Please upload email to EG/69/18/HH as lidsey statement

From: [REDACTED]
Sent: 11 November 2018 09:53
To: Daun Johnson
Subject: Re: RE: RE: 86 Elm Grove Barnham

BLOCK PLAN

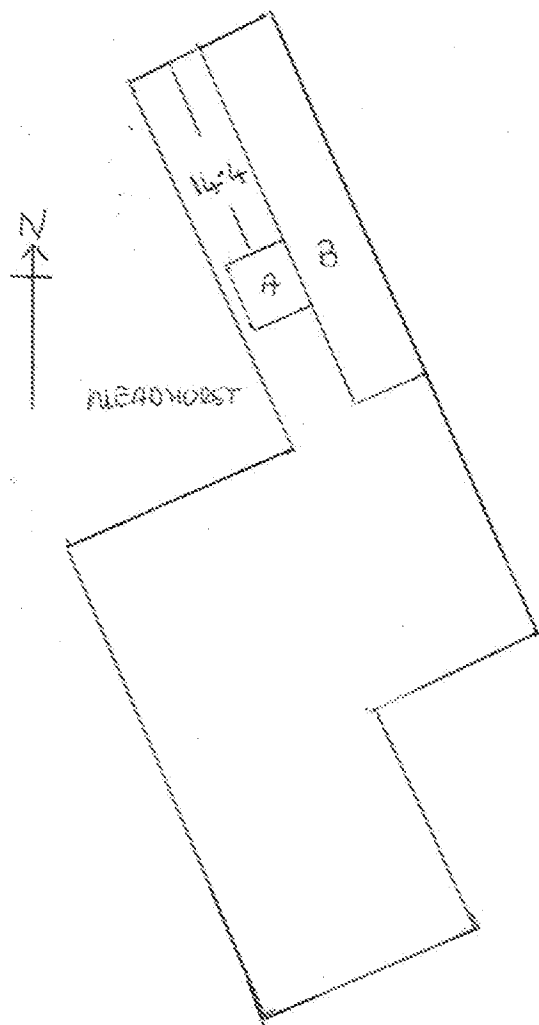
I have attached a revised block plan with a scale of 1:500 which I hope is now correct for the planning application.
